Planning Application Ref: AW/347/21/T

Location: Runnymede, 221 Aldwick Road, Bognor Regis, PO21 3QG

Description of works: Fell 1no. London plane tree

Comments on Application:

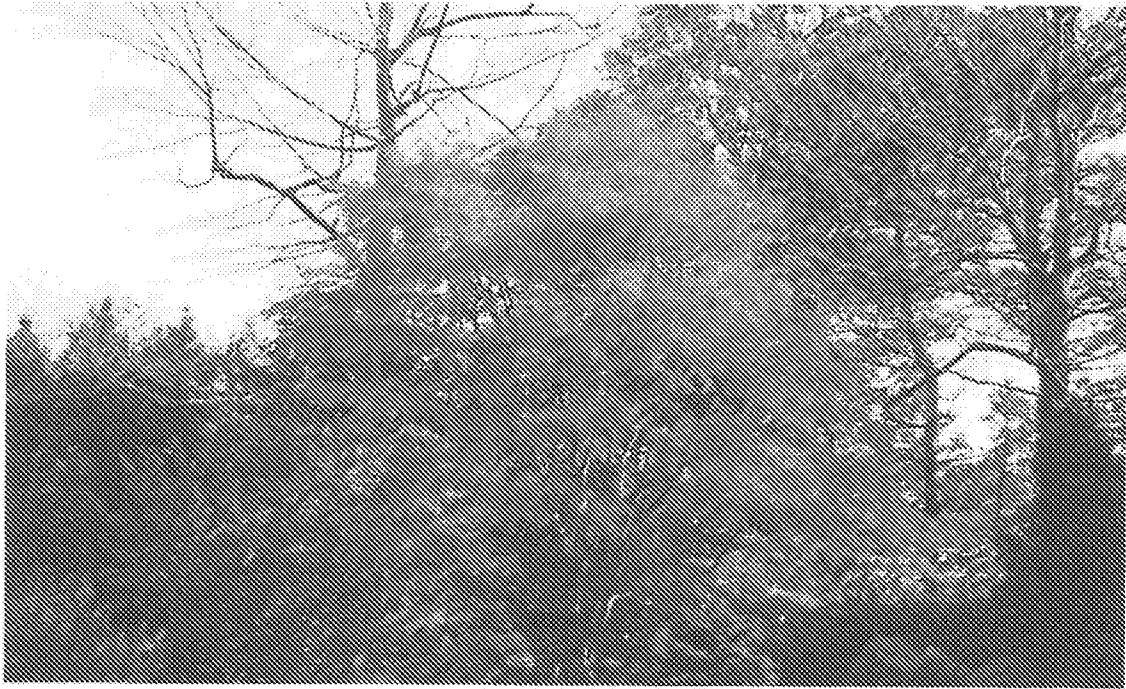
- It is possible to achieve adequate clearance of the streetlight column and allow for adequate light dispersal, without recourse to felling. A continuation of the pruning regime would be satisfactory in that regard.

- No evidence has been provided to confirm the presence of problematic root material within the subterranean apparatus, and where it does occur; can often be satisfactorily dealt with and permit retention of the parent tree.

- Root heave to the driveway is significant and likely to increase in severity, due to proximity of the tree and its high growth potential. It is unlikely that problematic roots can be removed due to their importance for the tree's structural integrity and no reasonable engineering solution could be employed for effective long-term reconstruction of the driveway with retention of the tree.

- Once the tree has been felled (and either grubbed or ground out) then a replacement tree is to be planted due East and to within 5metres, to occupy a prominent and near central position on the front lawn, to facilitate uniform/unconstrained development of limb and branch framework.
